Re: Application for Conditional Use Permit, CU-14-00001, GT Ranch

I am writing concerning an Application for a Conditional Use Permit CU-14-00001. The project is G T ranch. I have concerns regarding the Notice of Application as well as the project.

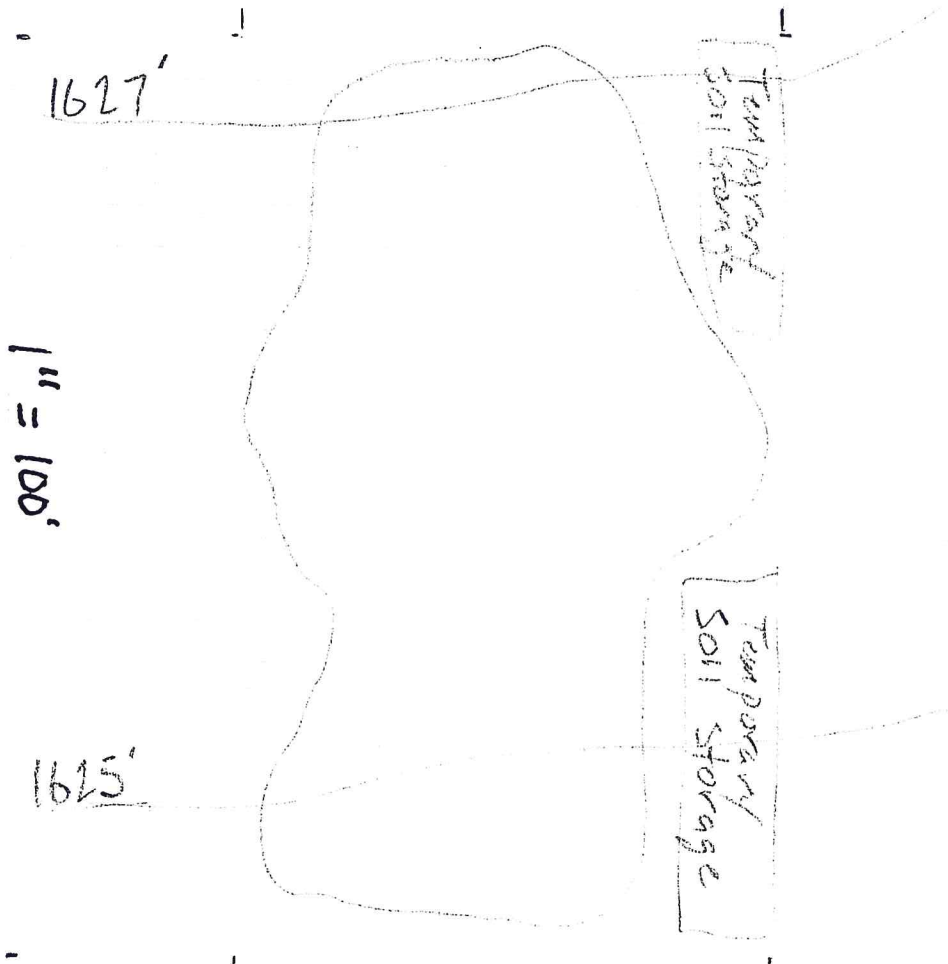
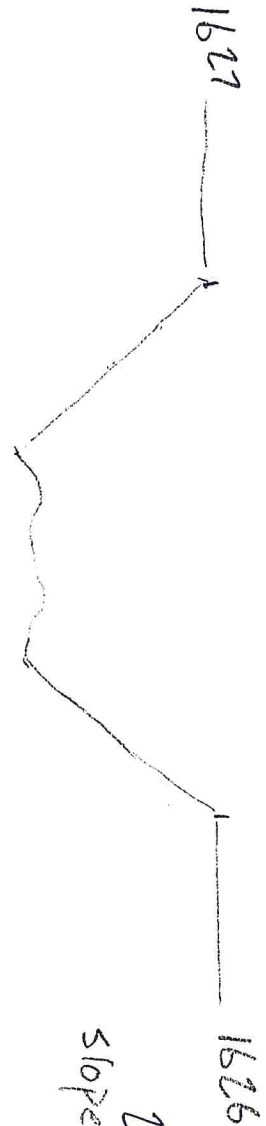
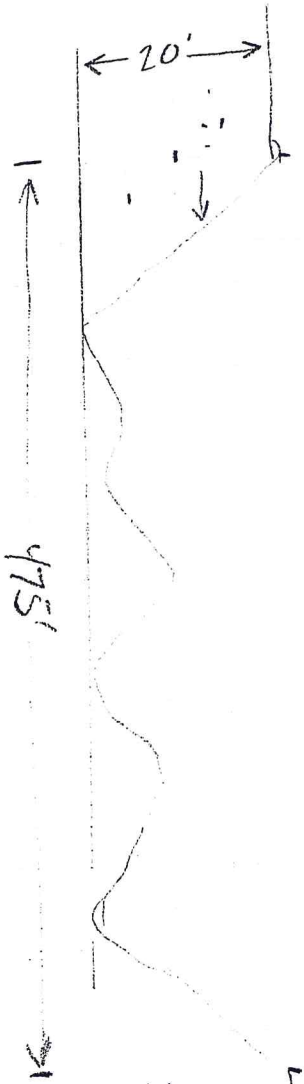
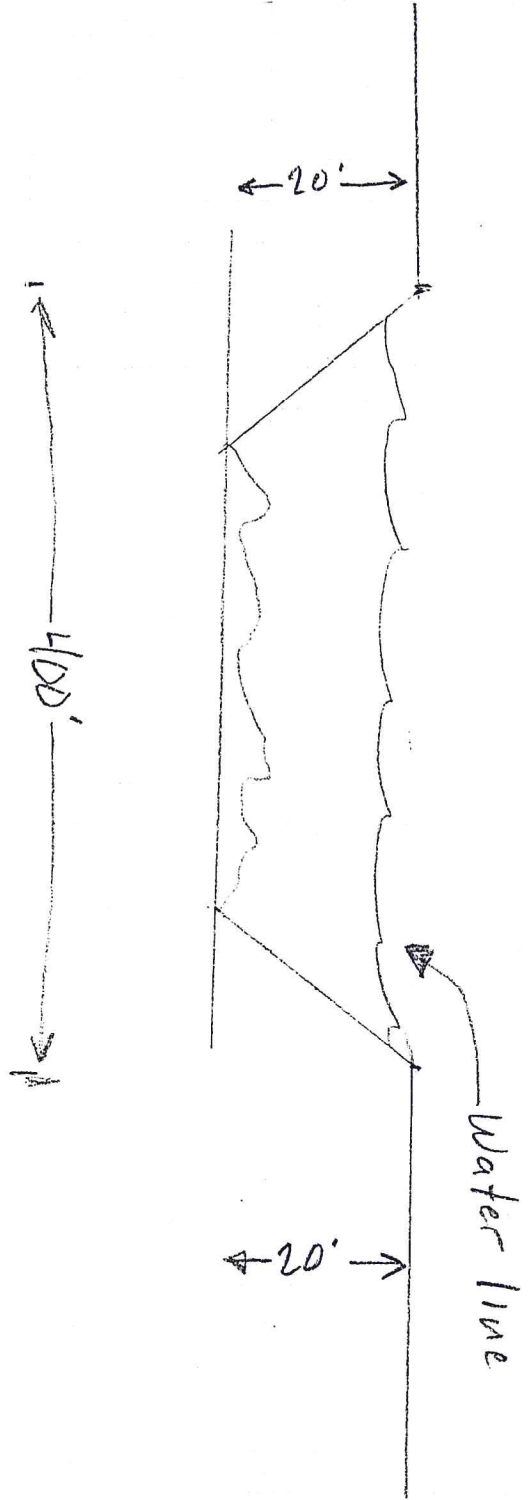
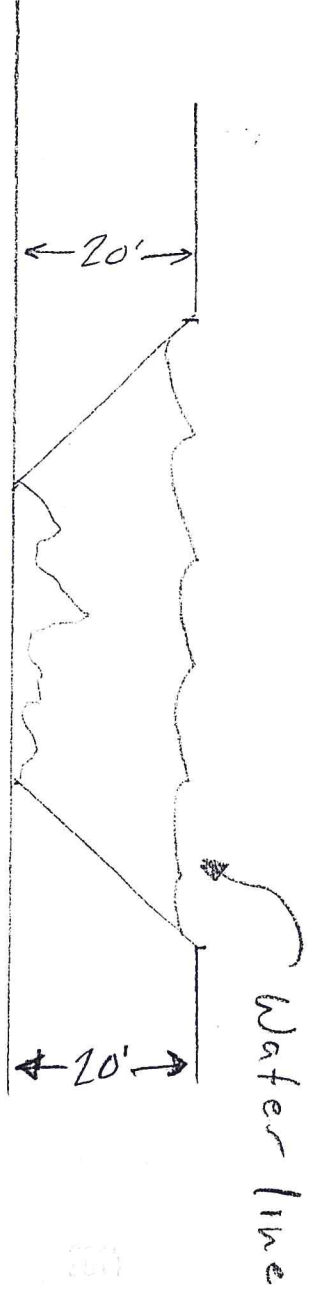
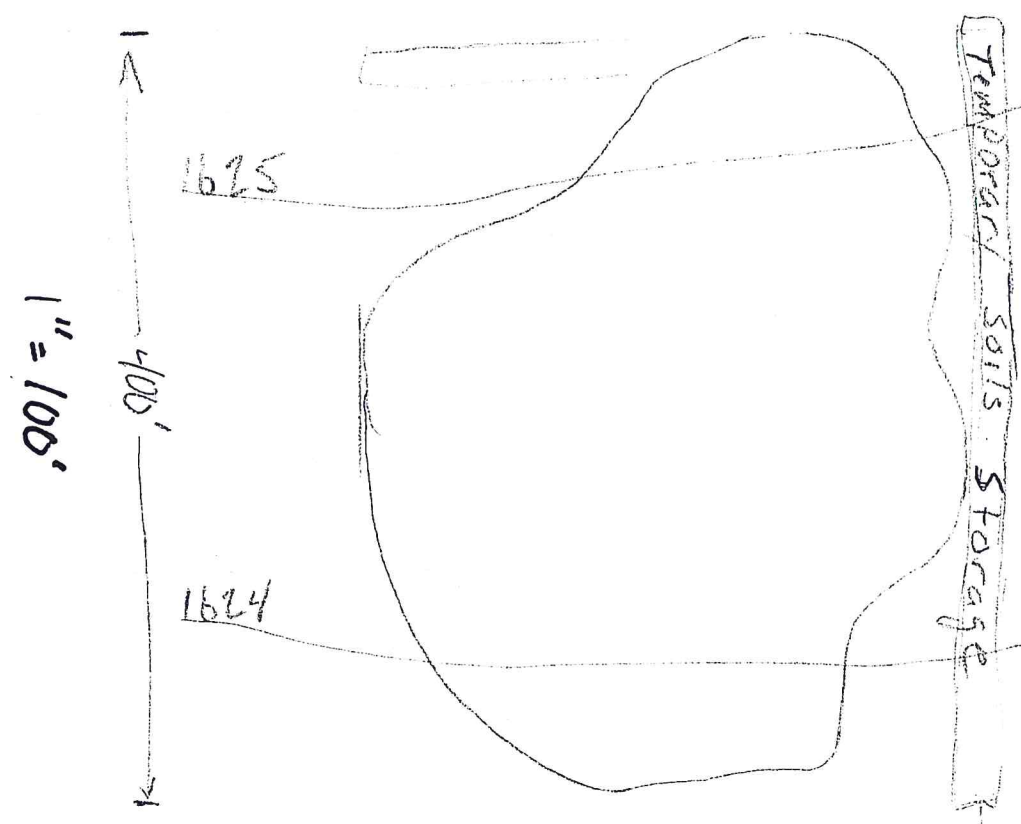
All of the access points require crossing the Thorp Mill Ditch. At least one of the access points indicated on the maps provided would require constructing a roadway across the Thorp Mill Ditch. As their answer was "NO", no plans for the construction of this roadway or bridge were provided. The Thorp Mill Ditch crosses the GT Ranch and at the location of the proposed ponds, the Thorp Mill Ditch is located between the proposed ponds and the Burlington Northern Railroad Tracks. The waters from the Thorp Mill Ditch return to the Yakima River if not being diverted to my property for irrigation and stock water as per our Water Right. How close will the ponds be located to the Thorp Mill Ditch? This was not addressed, as the Thorp Mill Ditch was not included as part of the SEPA Checklist. Will these ponds affect the flow of water in the Thorp Mill Ditch?
